6 October 2020

**SSD-7539 Darlington Terraces Mixed Use Development
University of Sydney 3rd Response to Submissions**

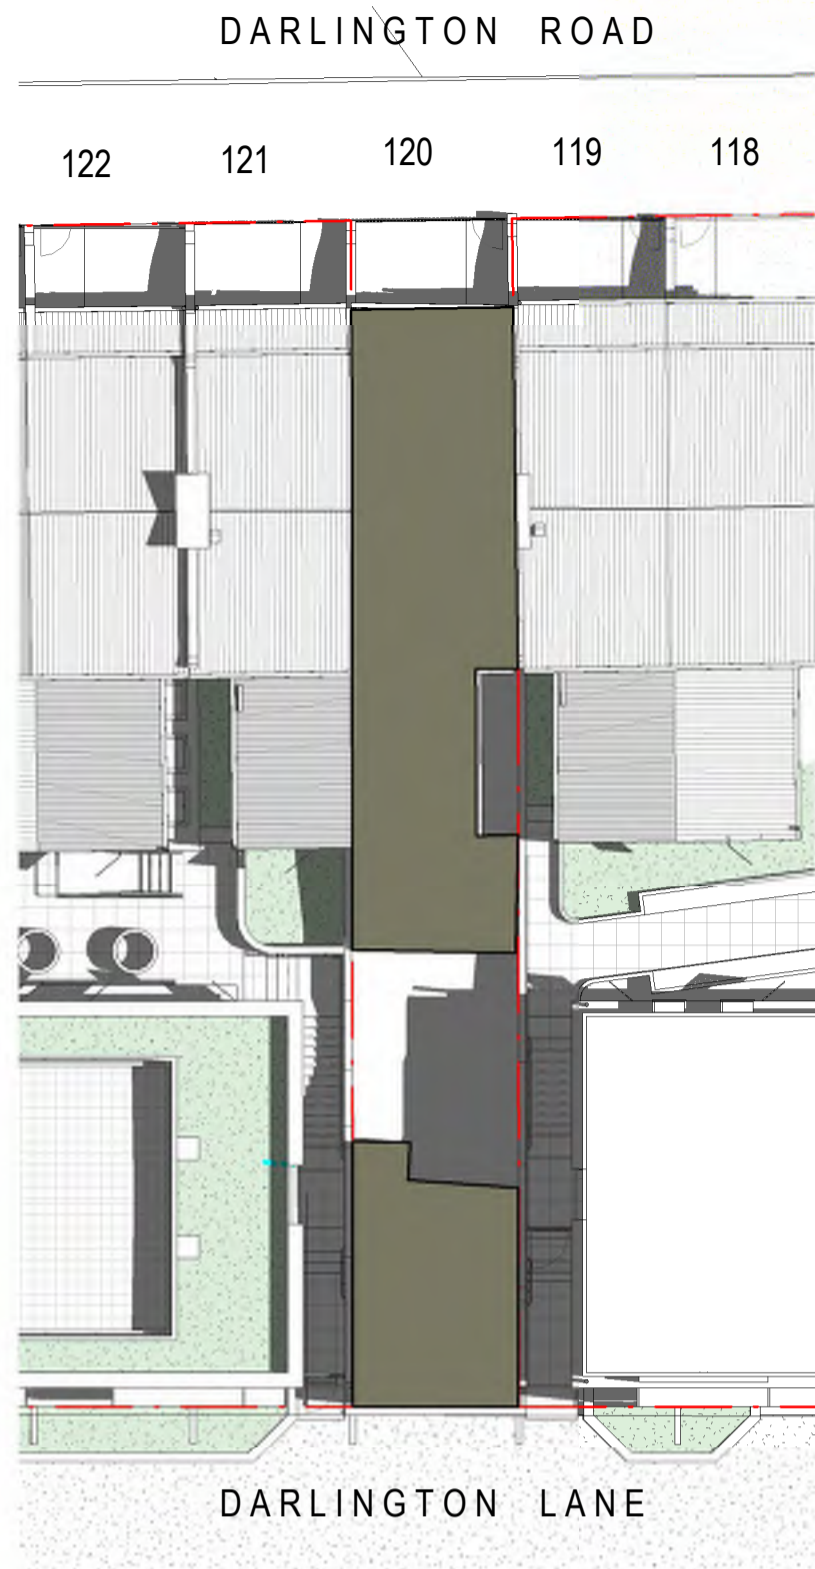
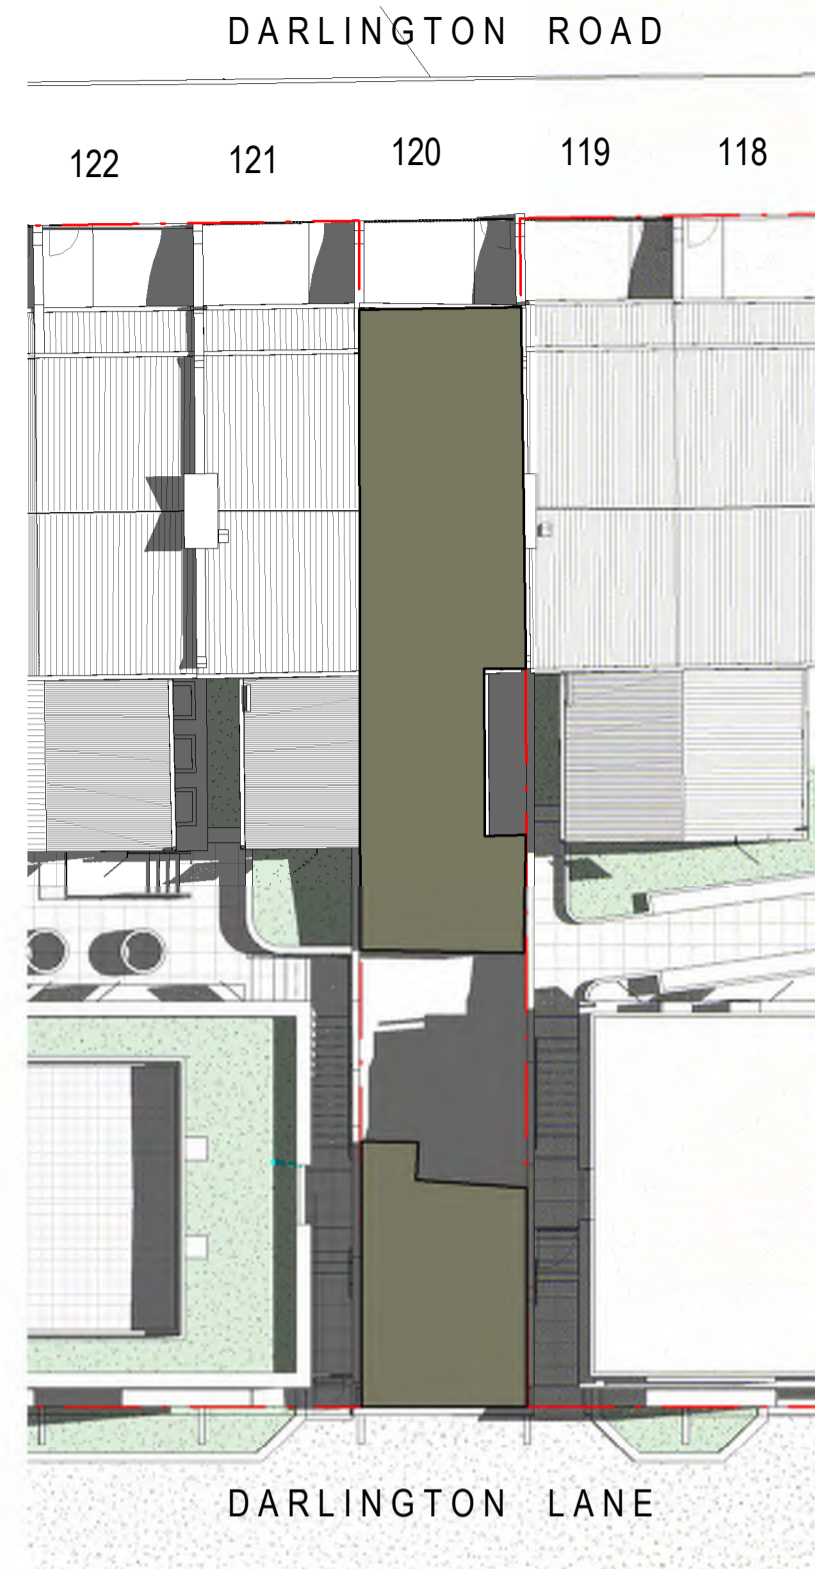
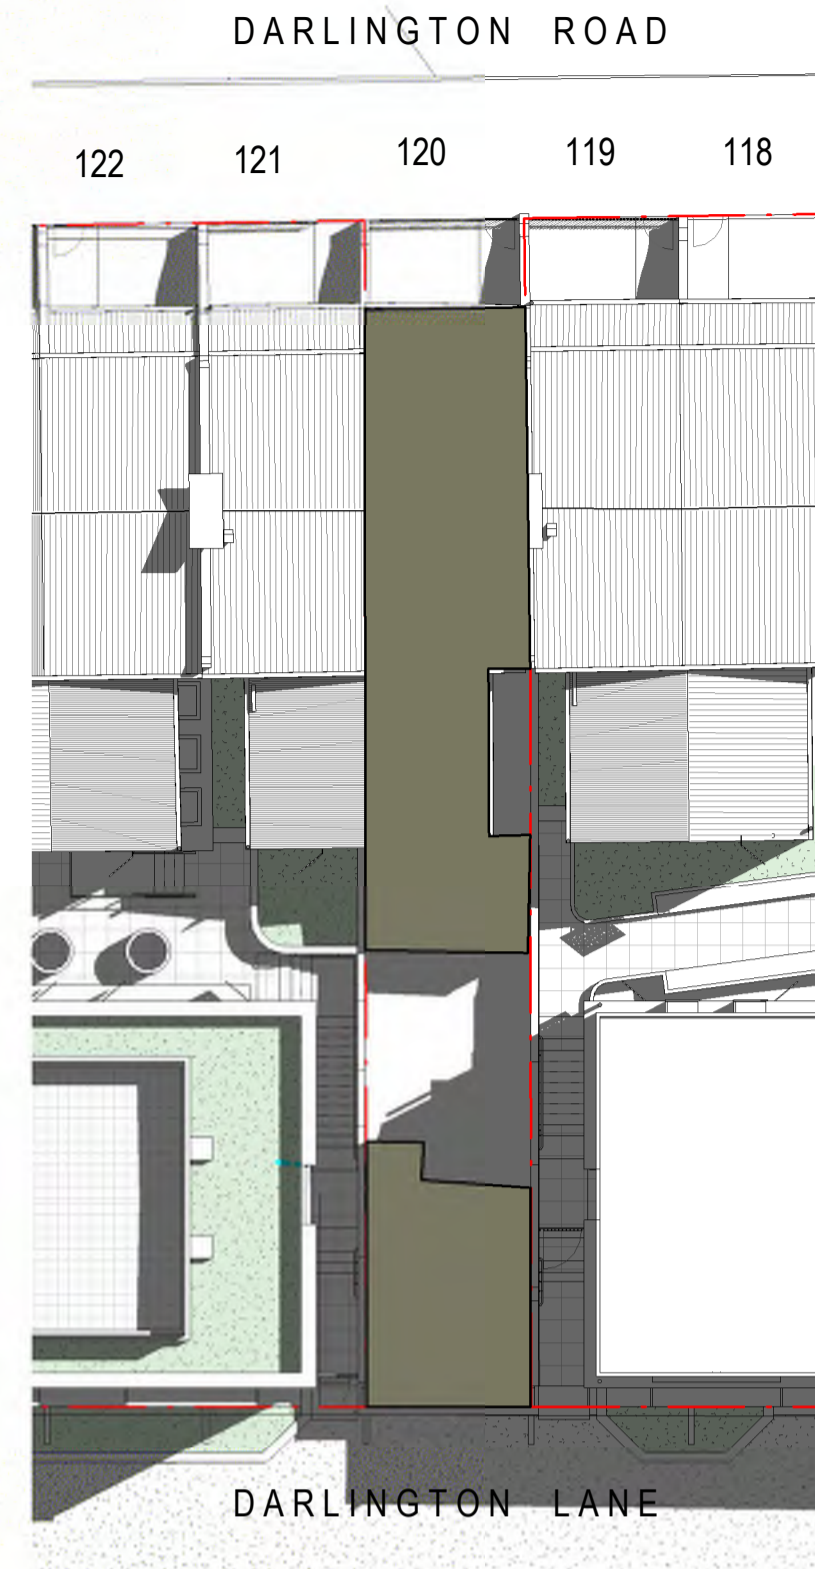
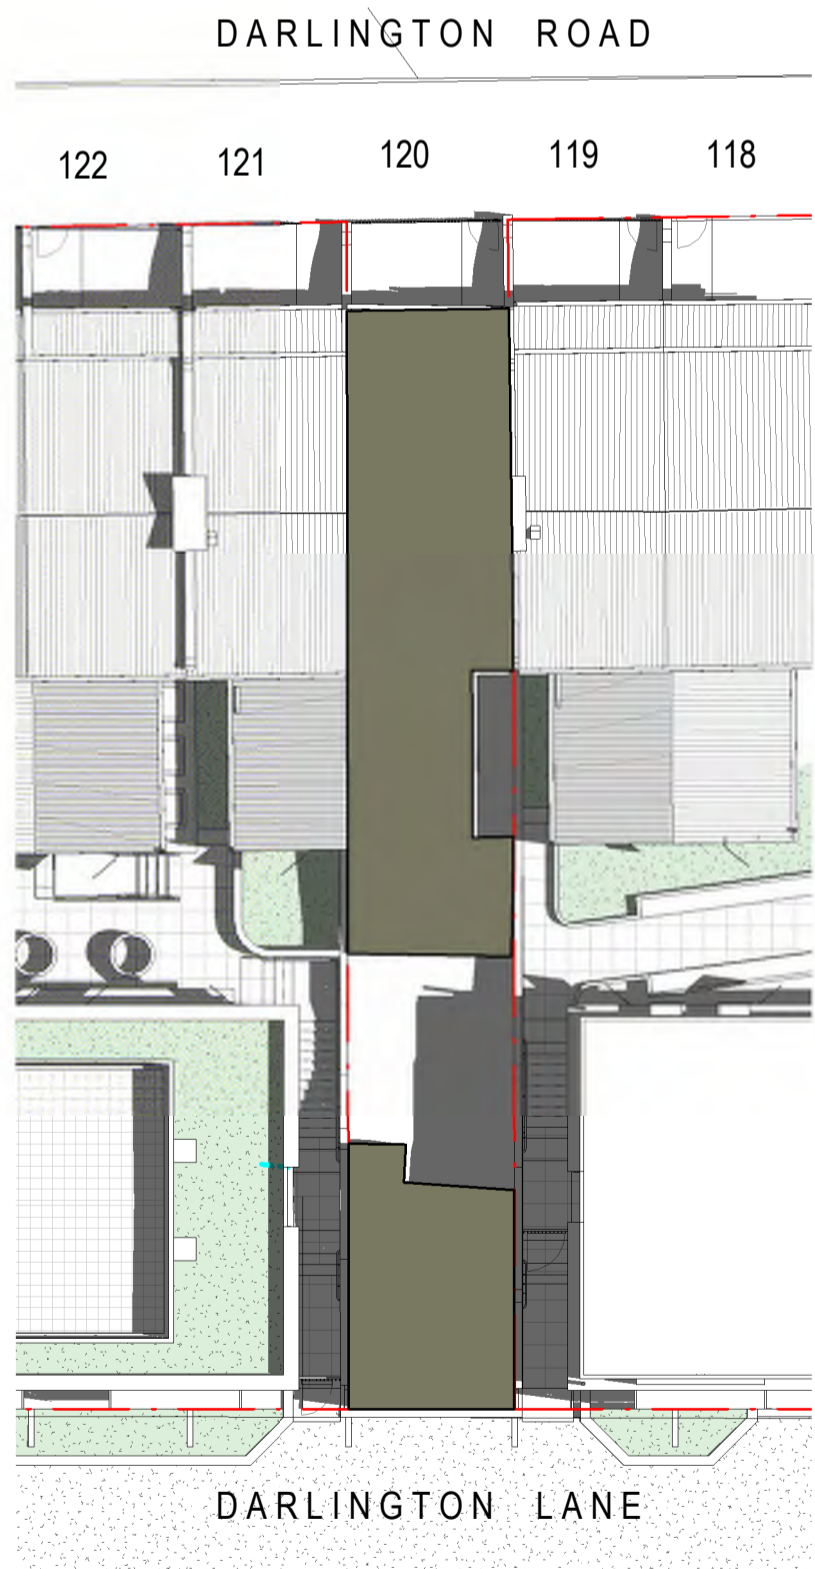
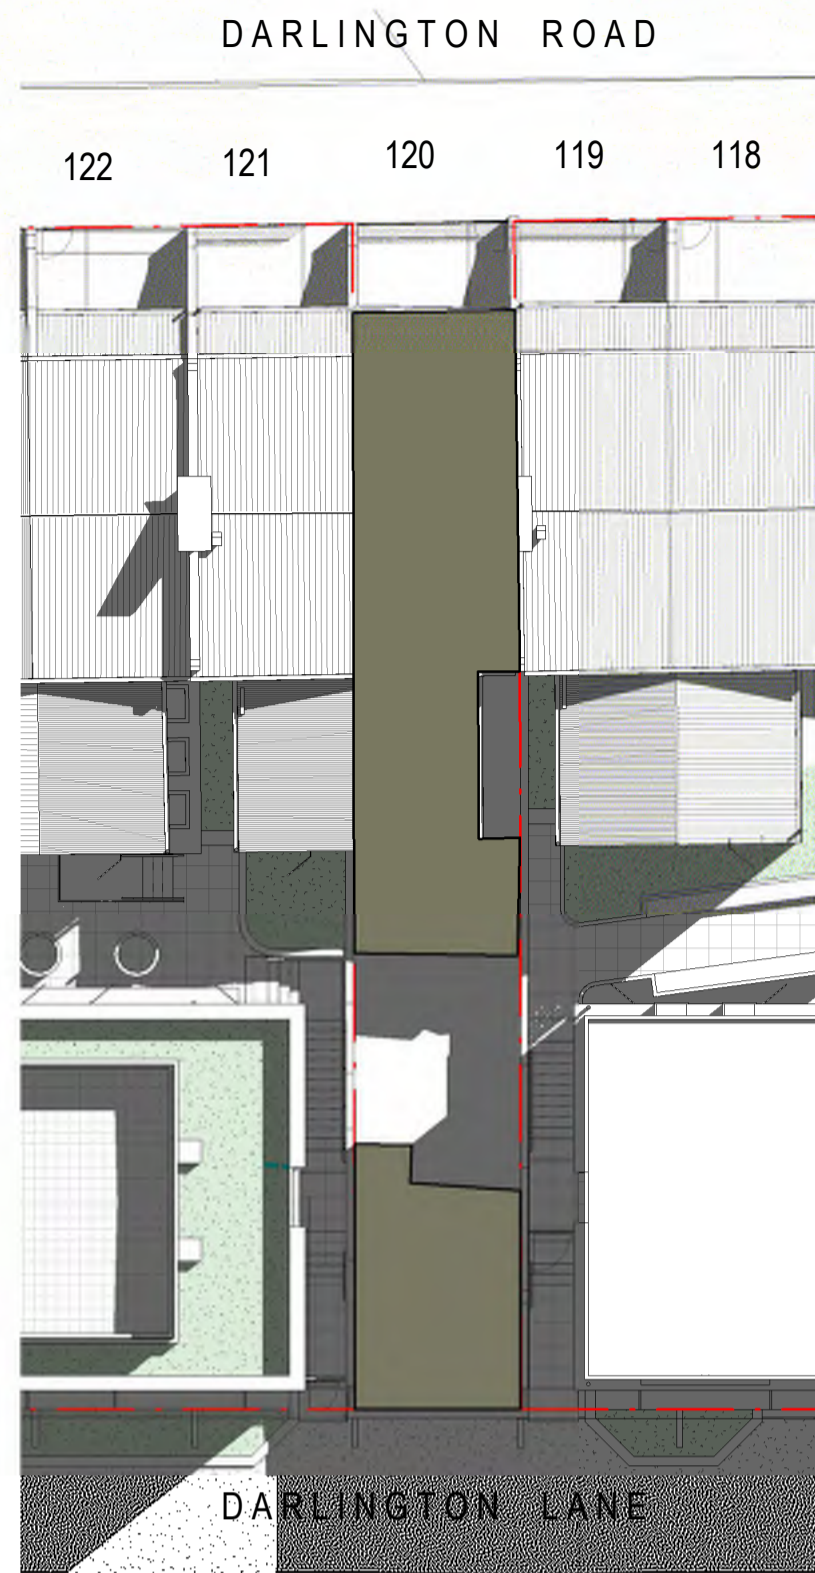
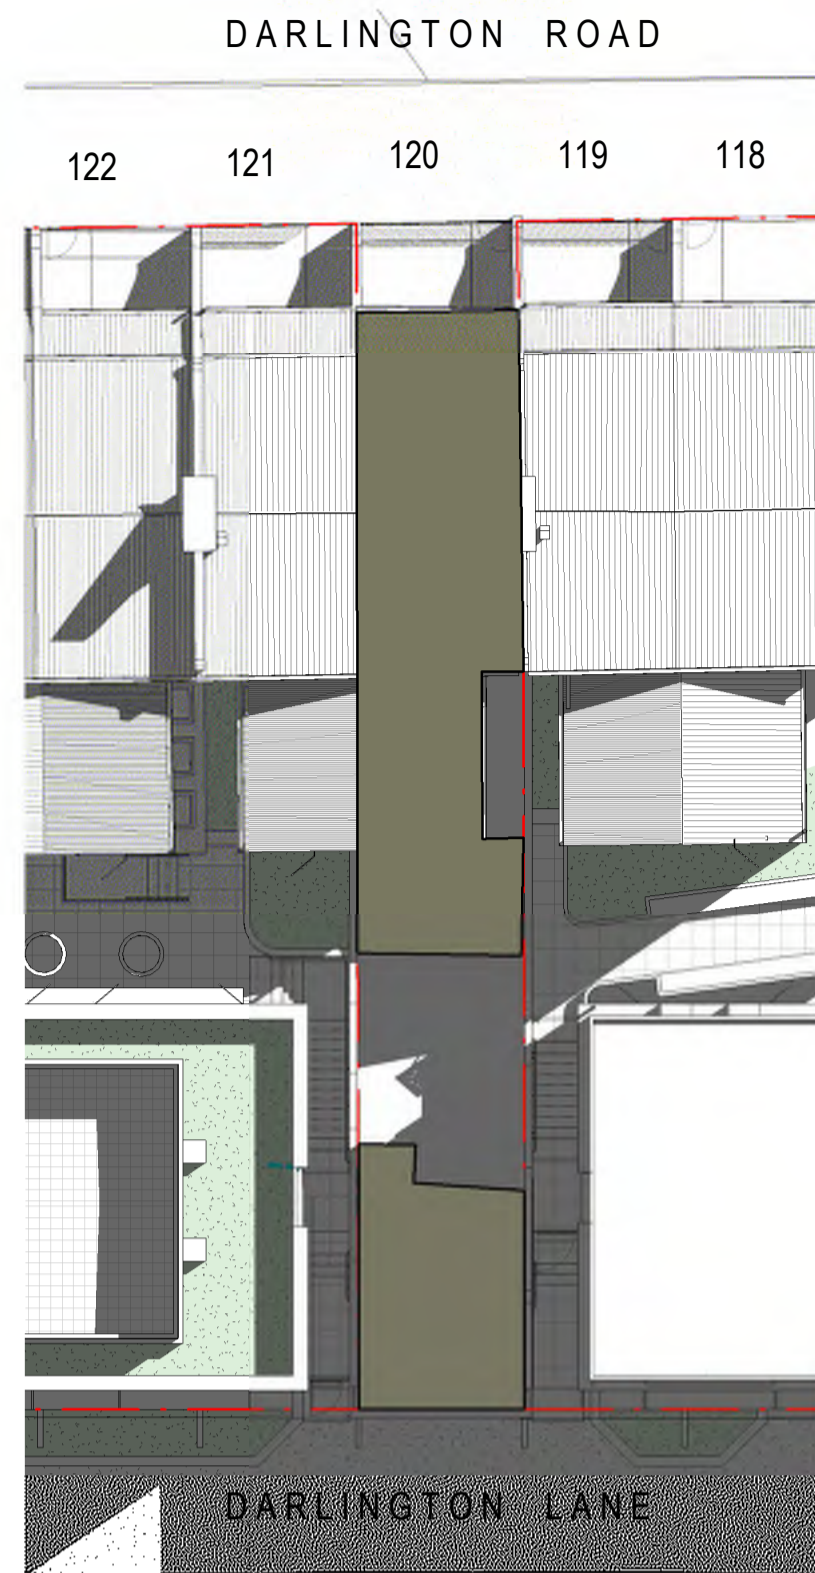
DPIE Issue 1: Overshadowing diagrams submitted with the amended proposal have not demonstrated that 120 Darlington Road receives sufficient solar access throughout the year. Building B must be revised to reduce the overshadowing impacts and improve solar access to 120 Darlington Road as per page 88 of Campus Improvement Program 2012-2020.

The result of this setback demonstrates No.120 Darlington Road will receive 2 hours of sun to at least 8m² of private open space all year round and will therefore satisfy the objectives of Sydney DCP 2012 clause 4.1.3.1 Solar Access. The reduction in overshadowing to No.120 is further ameliorated by removing the full length of the room to the north-west corner of the building and not just the overlapping corner with the Cox Richardson 'box'.
